Rezoning Transportation Analysis

Petition Number: 2023-017

Date	Description
06-28-23	First Review (PDM)
10-25-23	Second Review (JP)
11-27-23	Third Review (JP)
01-24-24	Fourth Review (JP)

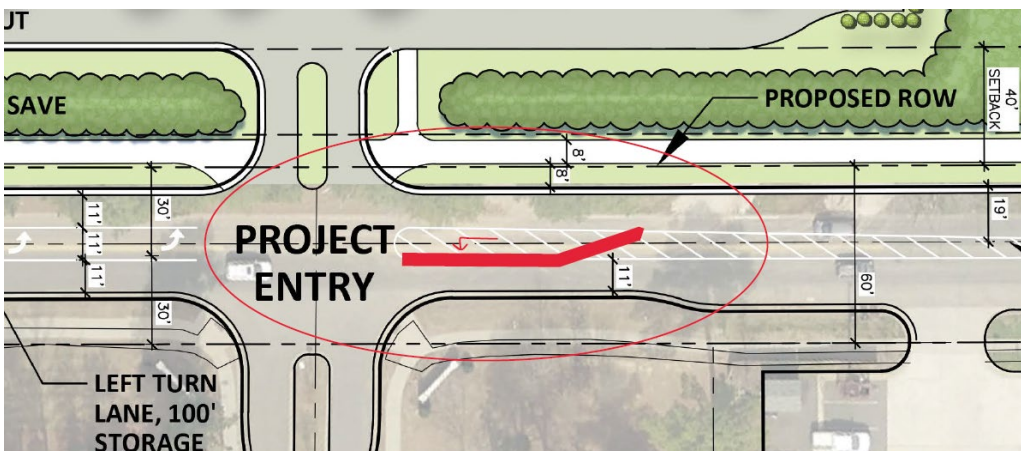
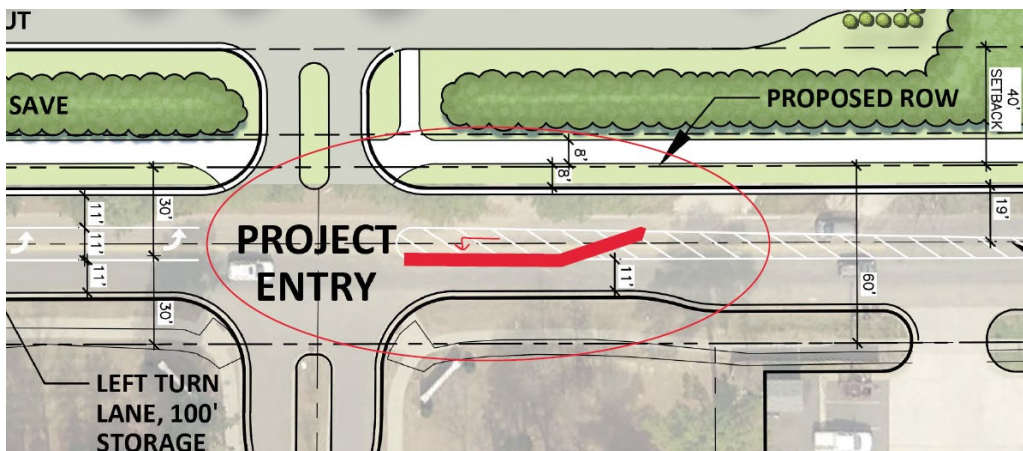
14. ~~New Comment 10.25.2023~~ – Revise proposed intersection improvements to construct matching short westbound left turn lane at location of full access driveway and newly constructed eastbound left turn lane.
